- 1 TITLE SHEET
- 2 GENERAL NOTES
- 3 TRAFFIC TABULATIONS
- 4 SIGNAGE AND PAVEMENT MARKINGS PLAN (WALKER ROAD)
- 5 SIGNAGE AND PAVEMENT MARKINGS PLAN (JANE LUNDEEN DRIVE)
- 6 SIGNAGE AND PAVEMENT MARKINGS PLAN (PINEHURST CIRCLE)

VICINITY MAP & GENERAL NOTES
Walker Rd./Jane Lundeen/Pinehurst
Signing and Striping Plan

JANE LUNDEEN DR. SIGNING AND STRIPING PLAN
Walker Rd./Jane Lundeen/Pinehurst
Signing and Striping Plan

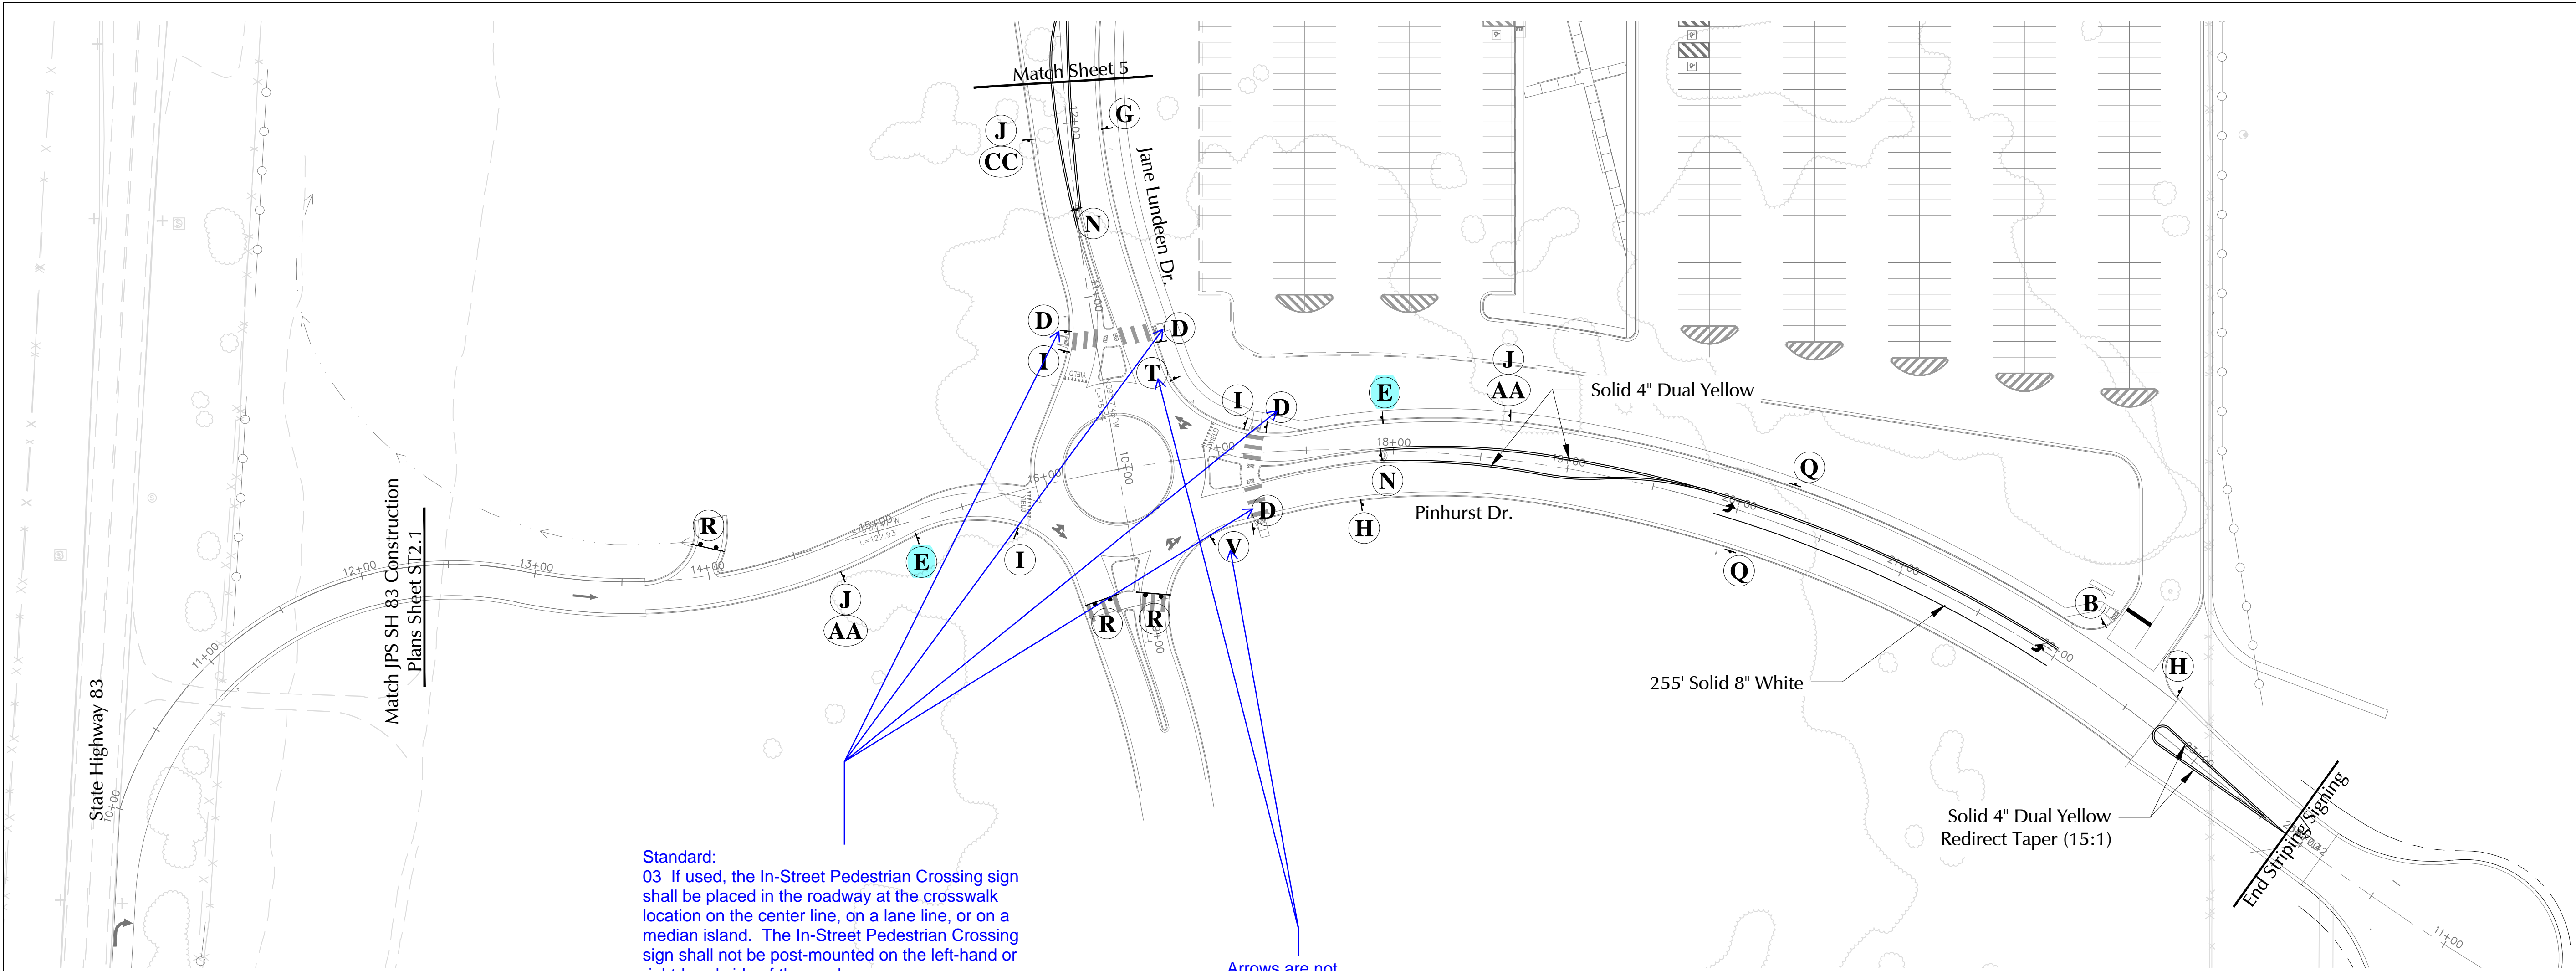
delete - covered by yield sign placement

Add "Fines Higher" placard

Delete placard, add advance street name.

Taper double yellow back?

delete or move north?

Use fluorescent with "school" placards
